Development Application Permit Review

June 21, 2019

Name:	Creekside at Lorson Ranch Filing No. 1 Final Plat	Application Type:	Final Plat
PCD Reference #:	SF-1913	Total Acreage:	83.09
		Total # of Dwelling Units:	235
Applicant / Owner:	Owner's Representative:	Dwelling Units Per 2.5 Acres:	7.07
Lorson, LLC	Core Engineering Group, LLC	Regional Park Area:	4
Jeff Mark		Urban Park Area:	4
212 N. Wahsatch Avenue, Suite 301	15004 1st Ave South	Existing Zoning Code:	PUD
Colorado Springs, CO 80903	Burnsville, MN 55306	Proposed Zoning Code:	PUD

MATCHLINE - SEE SHEET 6 OF 7

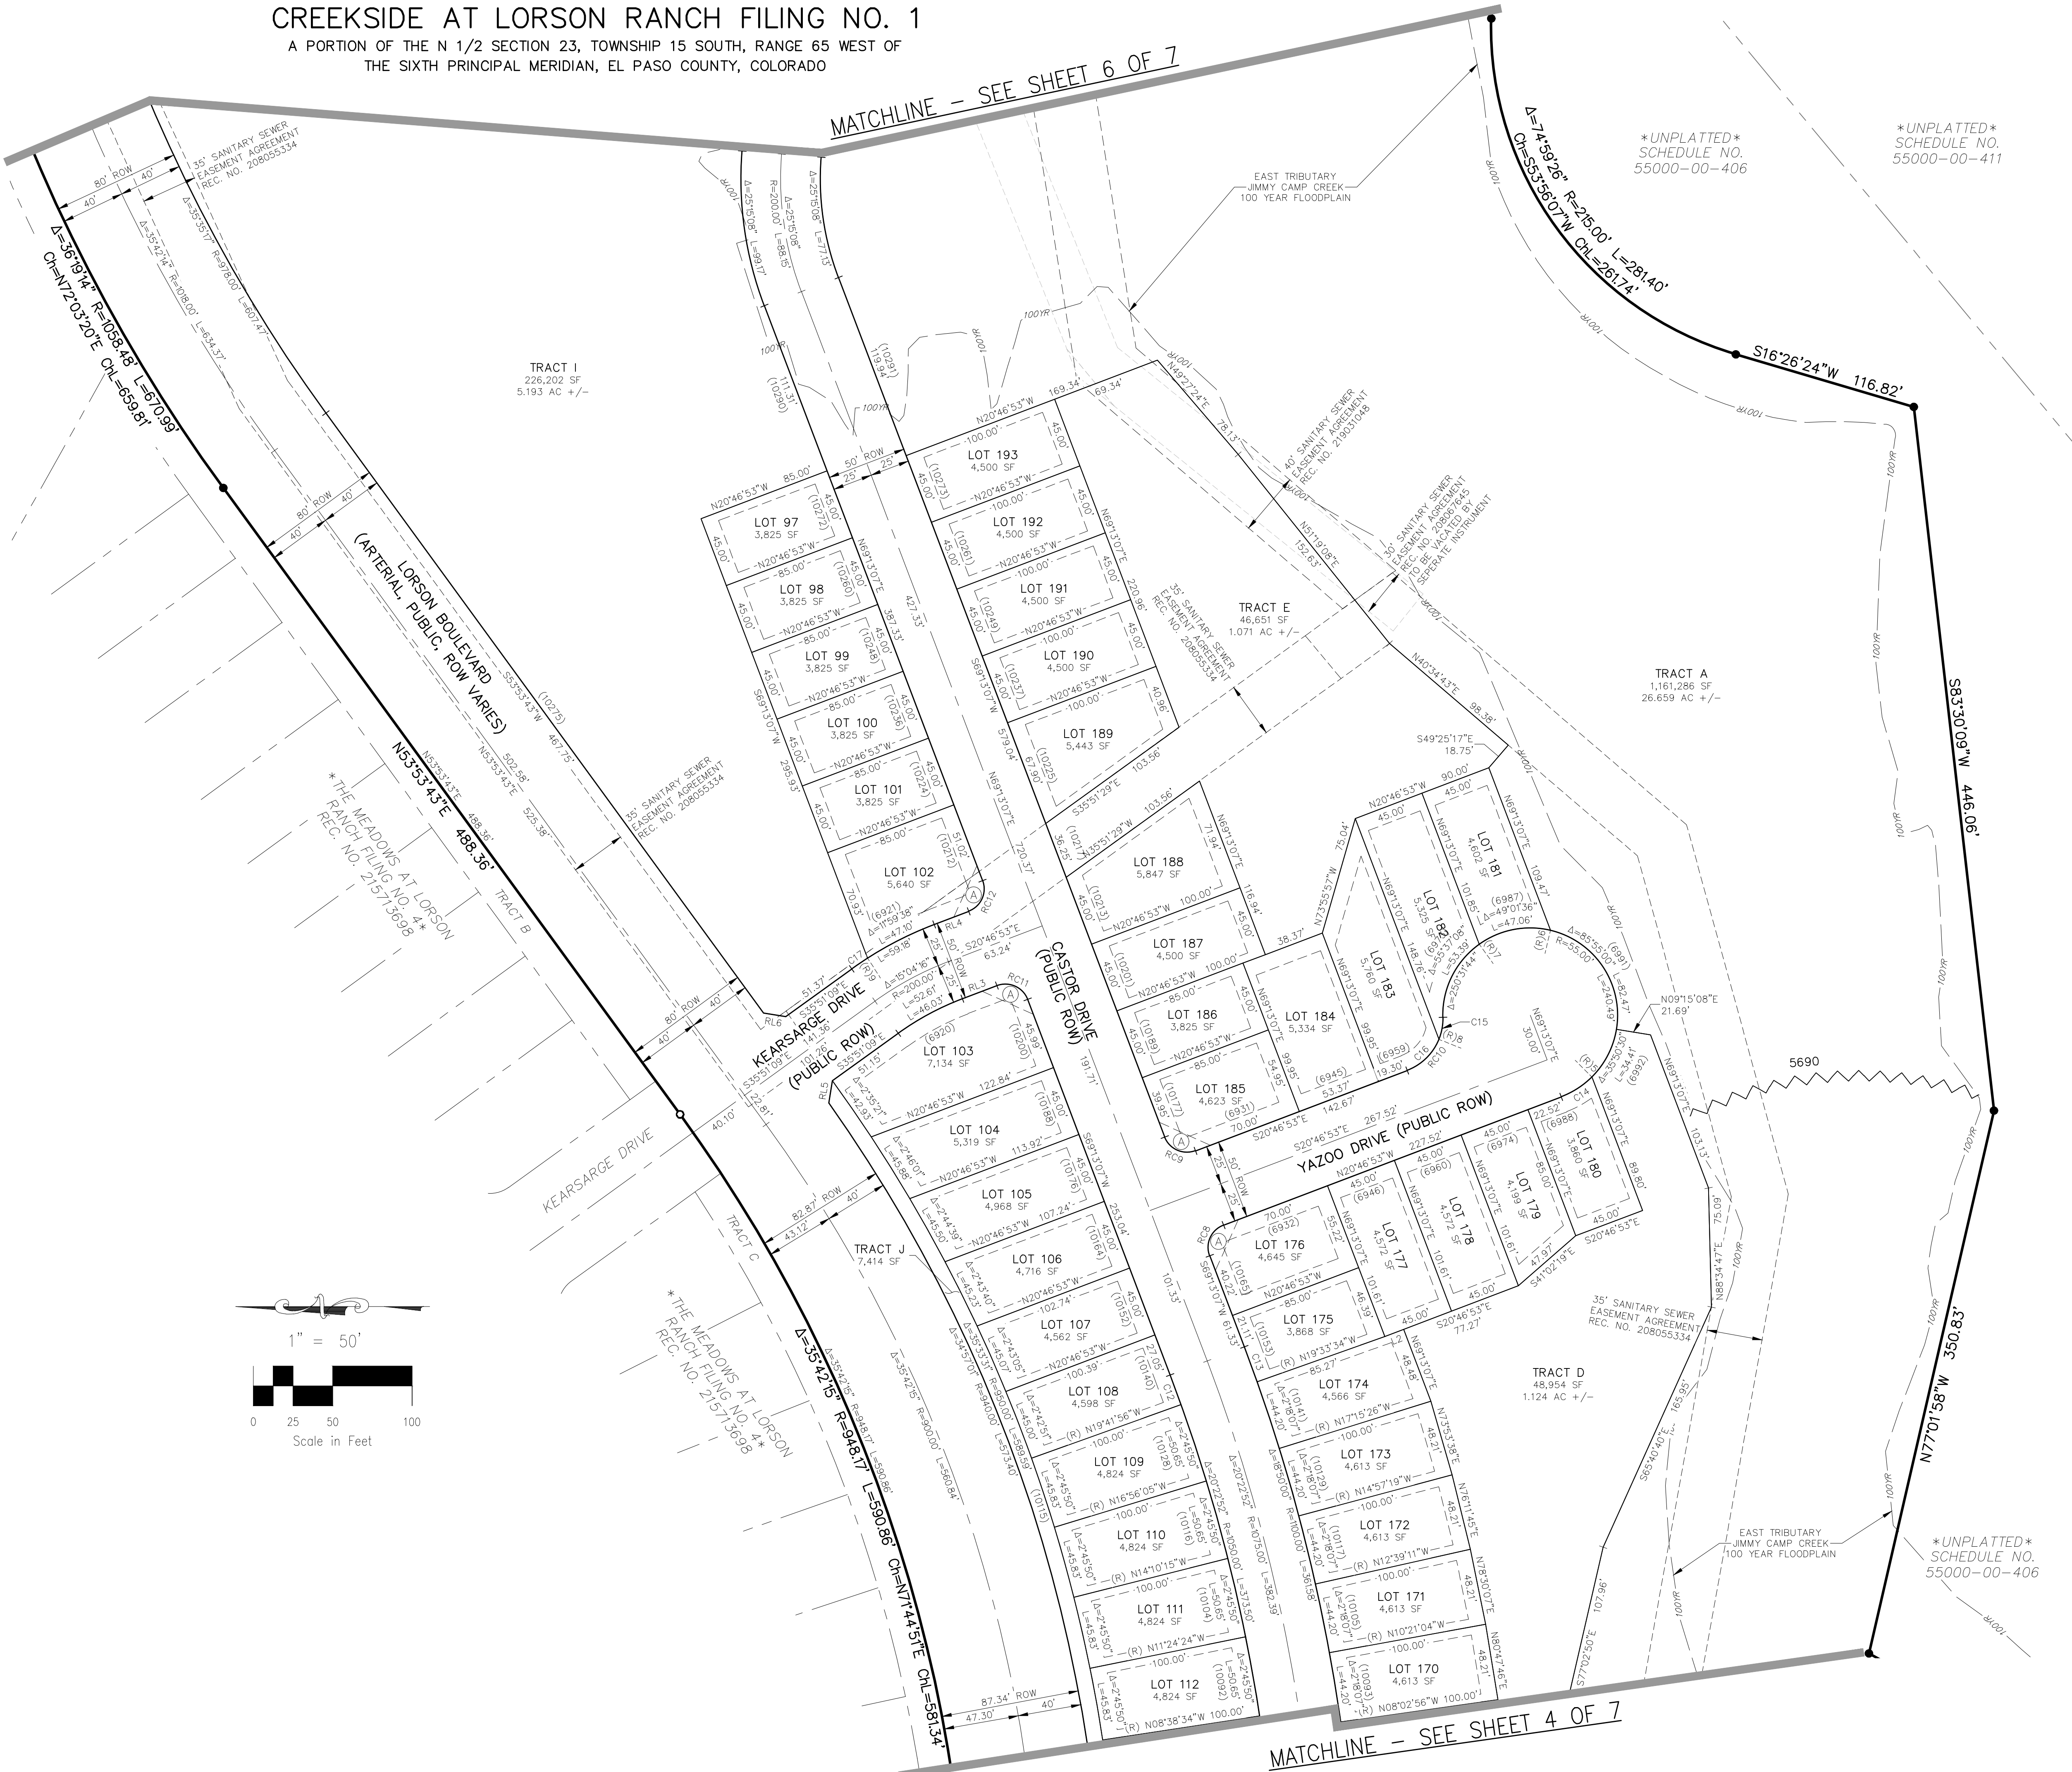
Staff Recommendation: Recommend to the Planning Commission and Board of County Commissioners that approval of Creekside at Lorson Ranch Filing No. 1 Final Plat include the following conditions: (1) show the non-County trails within Tracts A, B, and D on the final plat drawings; (2) Require fees in lieu of land for regional park purposes in the amount of \$107,160 and urban fees in the amount of \$67,680. A park lands agreement may be an acceptable alternative to urban park fees provided the agreement is approved by the County and executed prior to recording the final plat.
